ADDENDUM

Project: Science Building Research Wing Expansion

Addendum: No. 2

Date: April 29, 2004

THIRD & FOURTH FLOOR PLANS

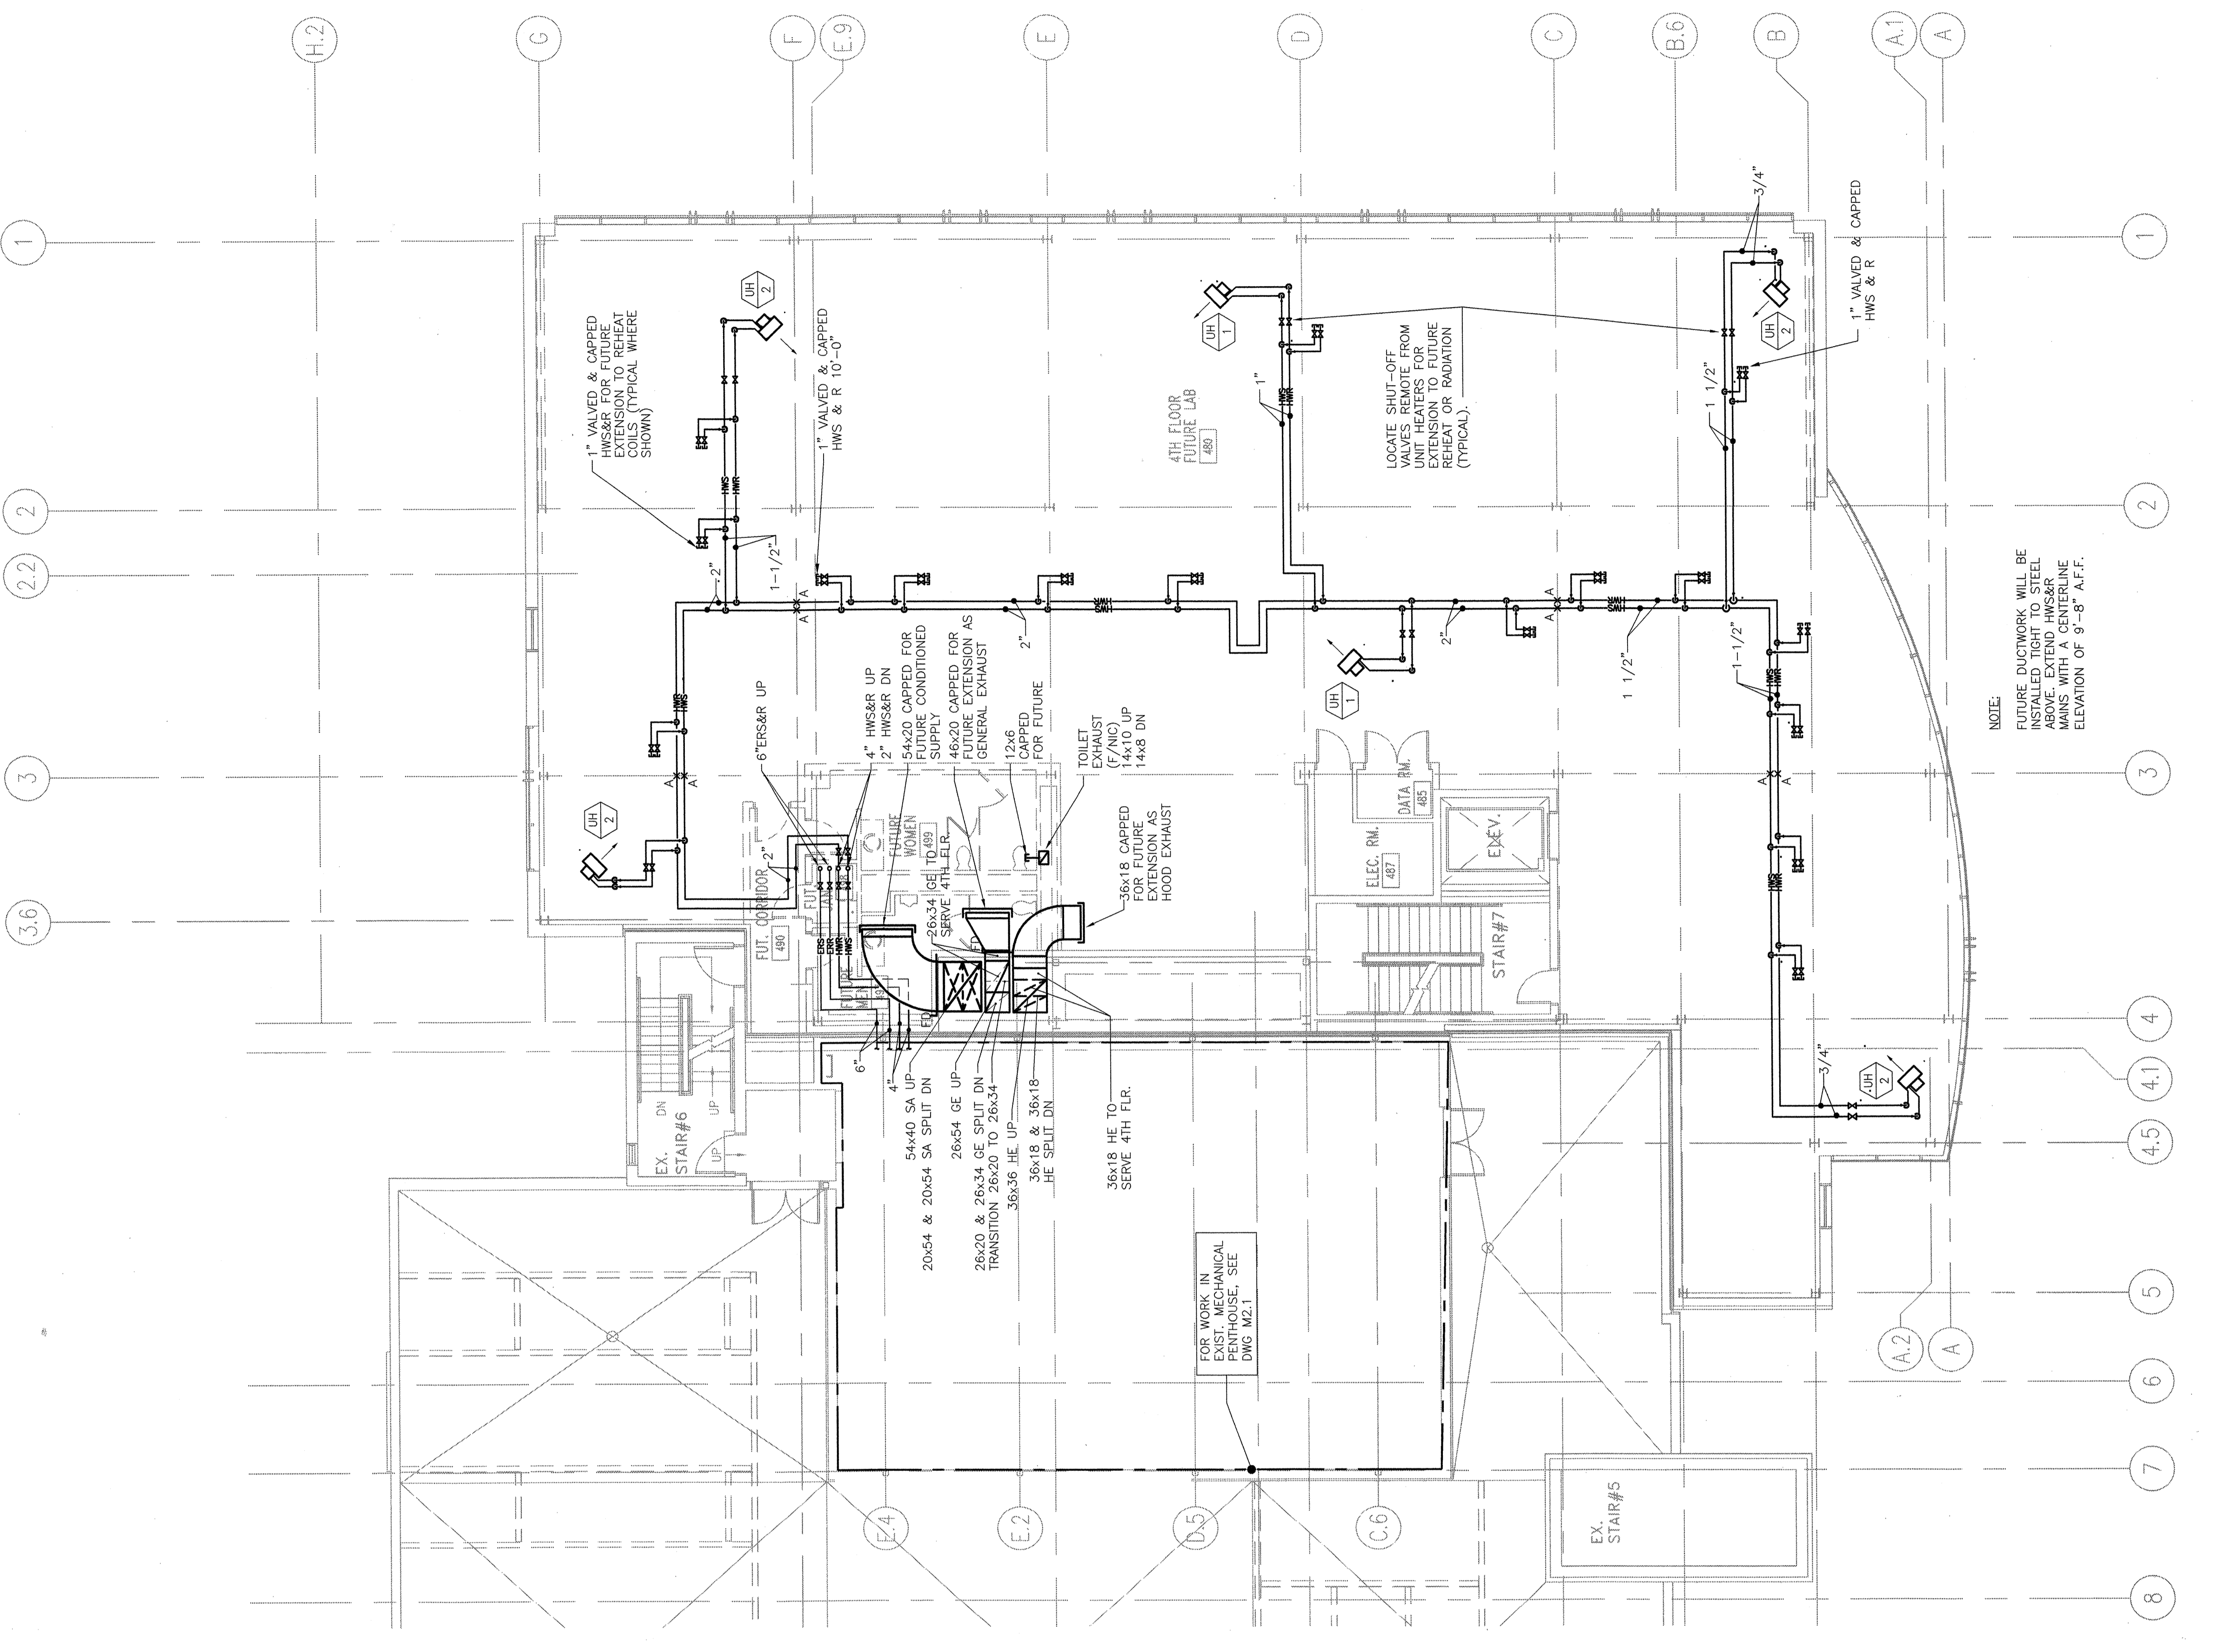
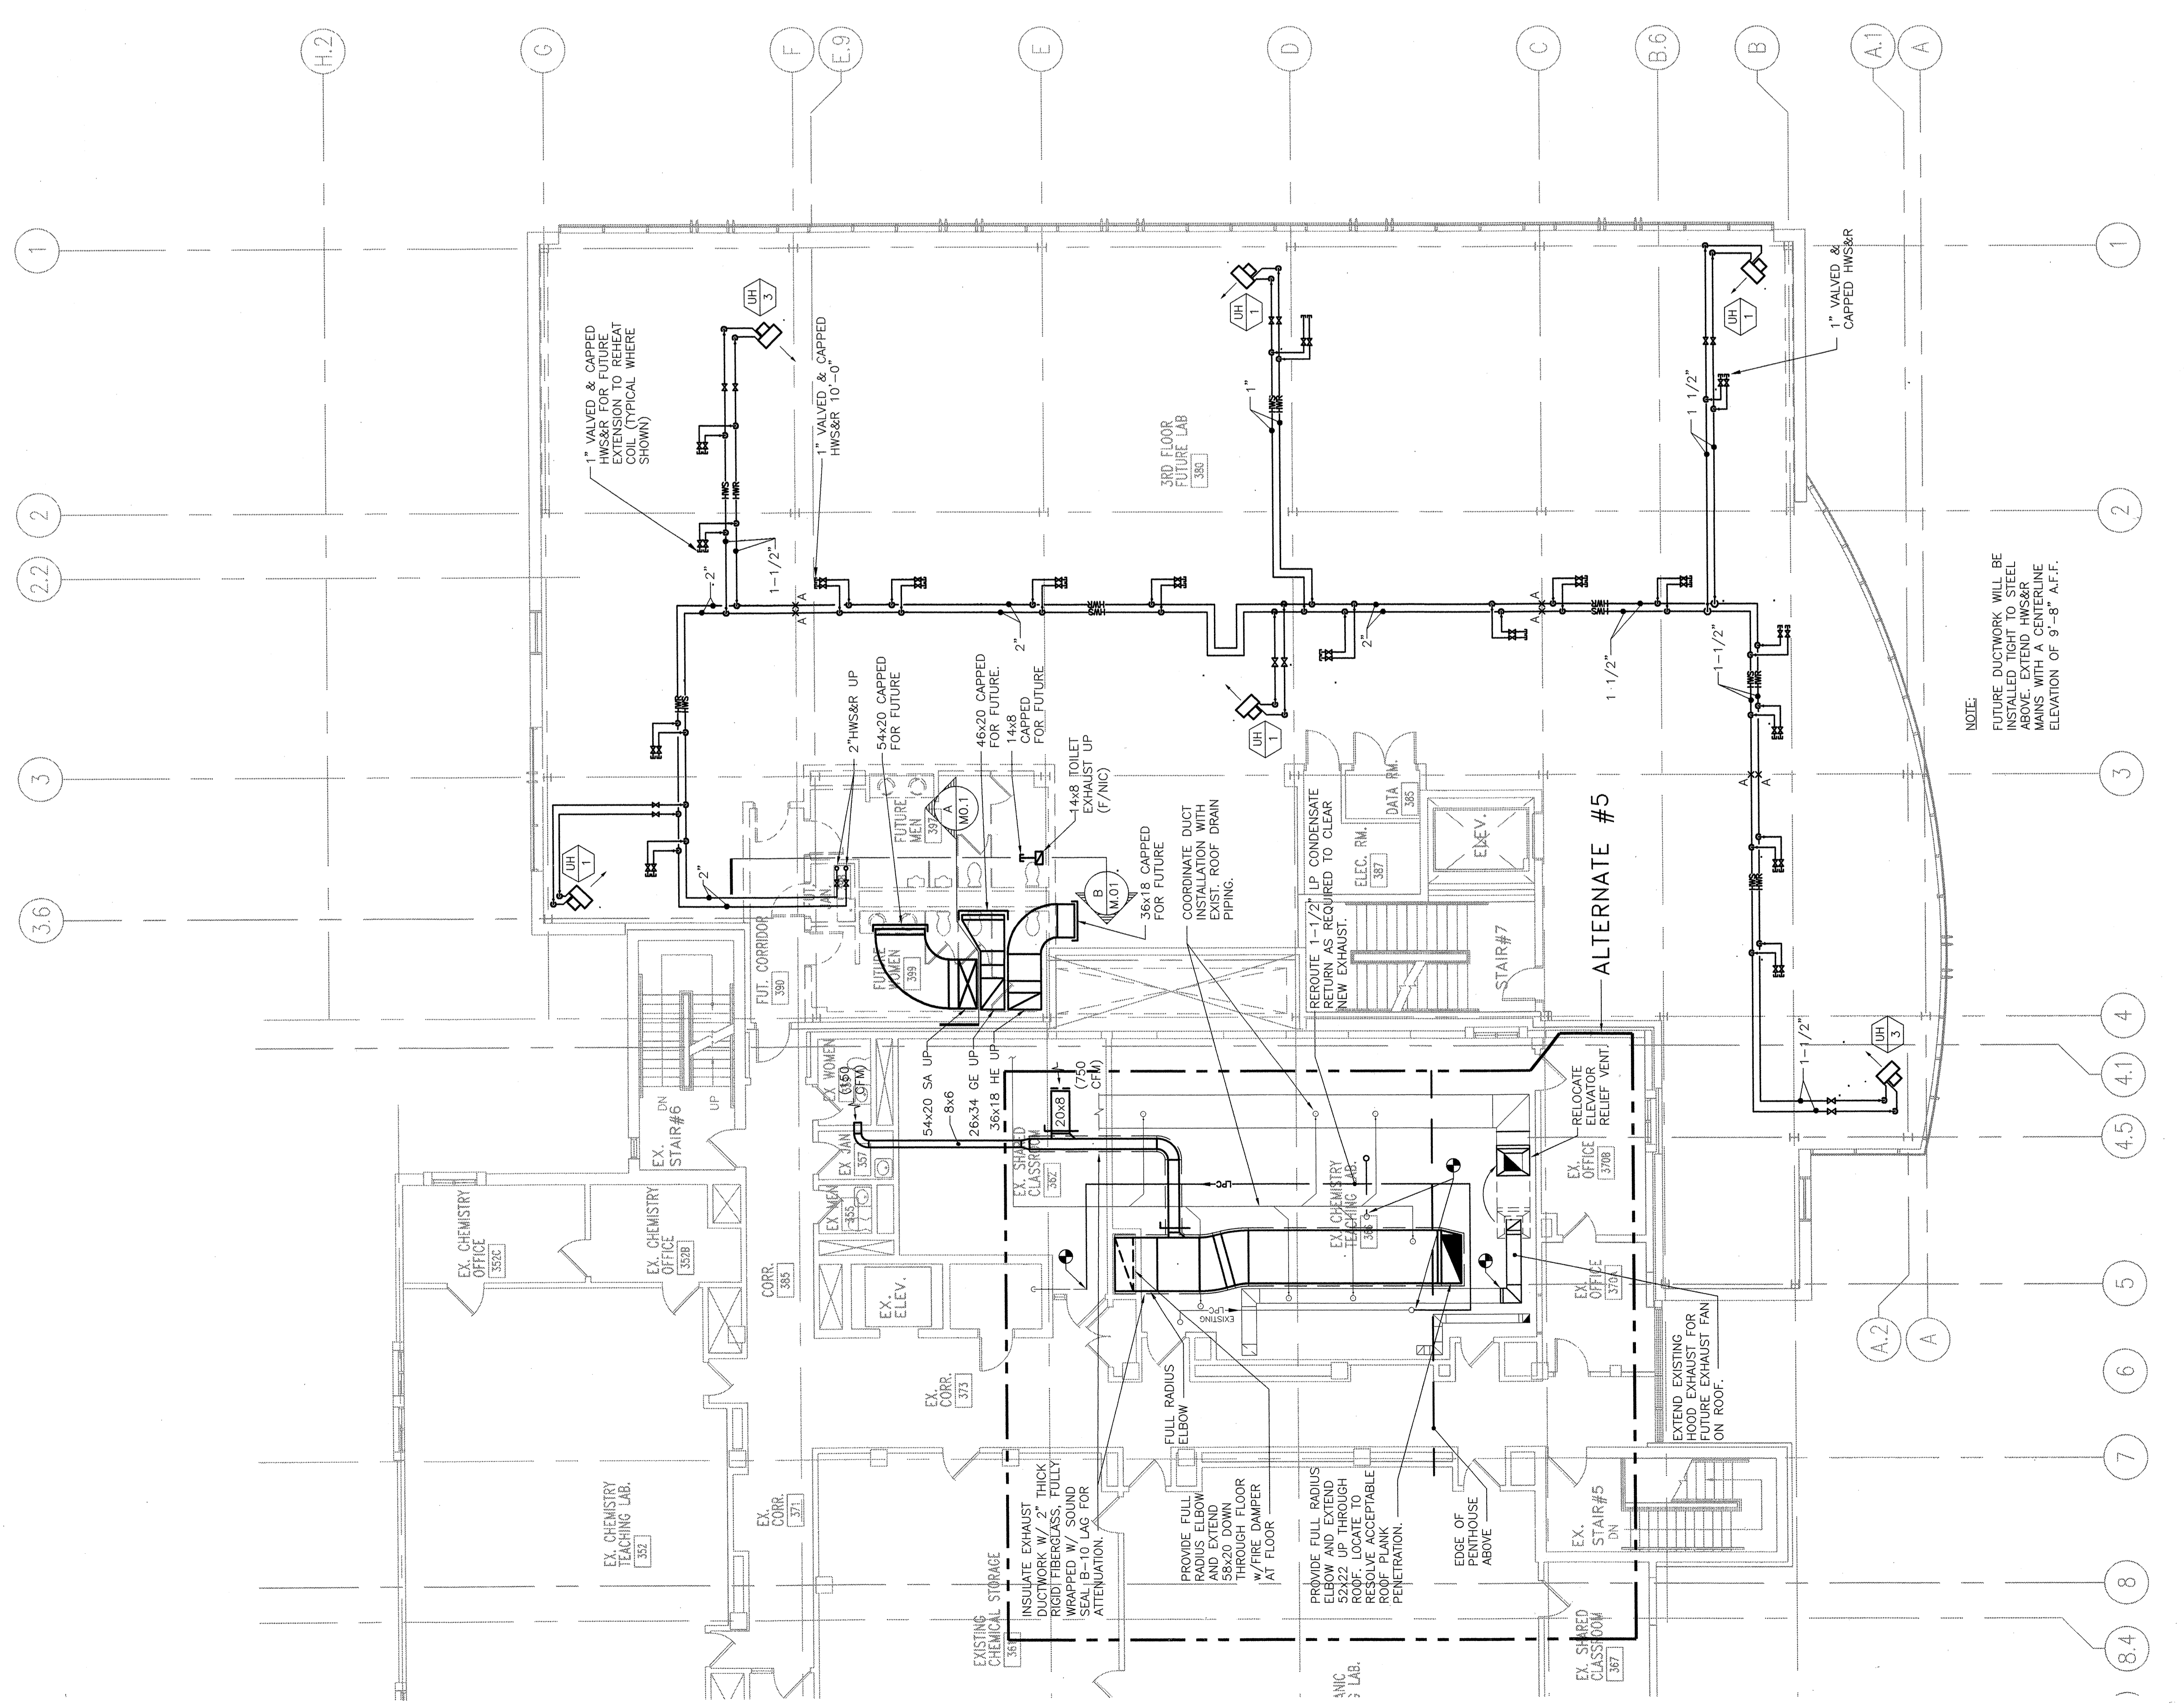
1. The Unit Heaters marked UH/1 on the Third and Forth Floor Plans are new, to be provided by the Contractor. (Only the Unit Heaters marked UH/1 on the Fifth Floor Plan will be from USM storage.)
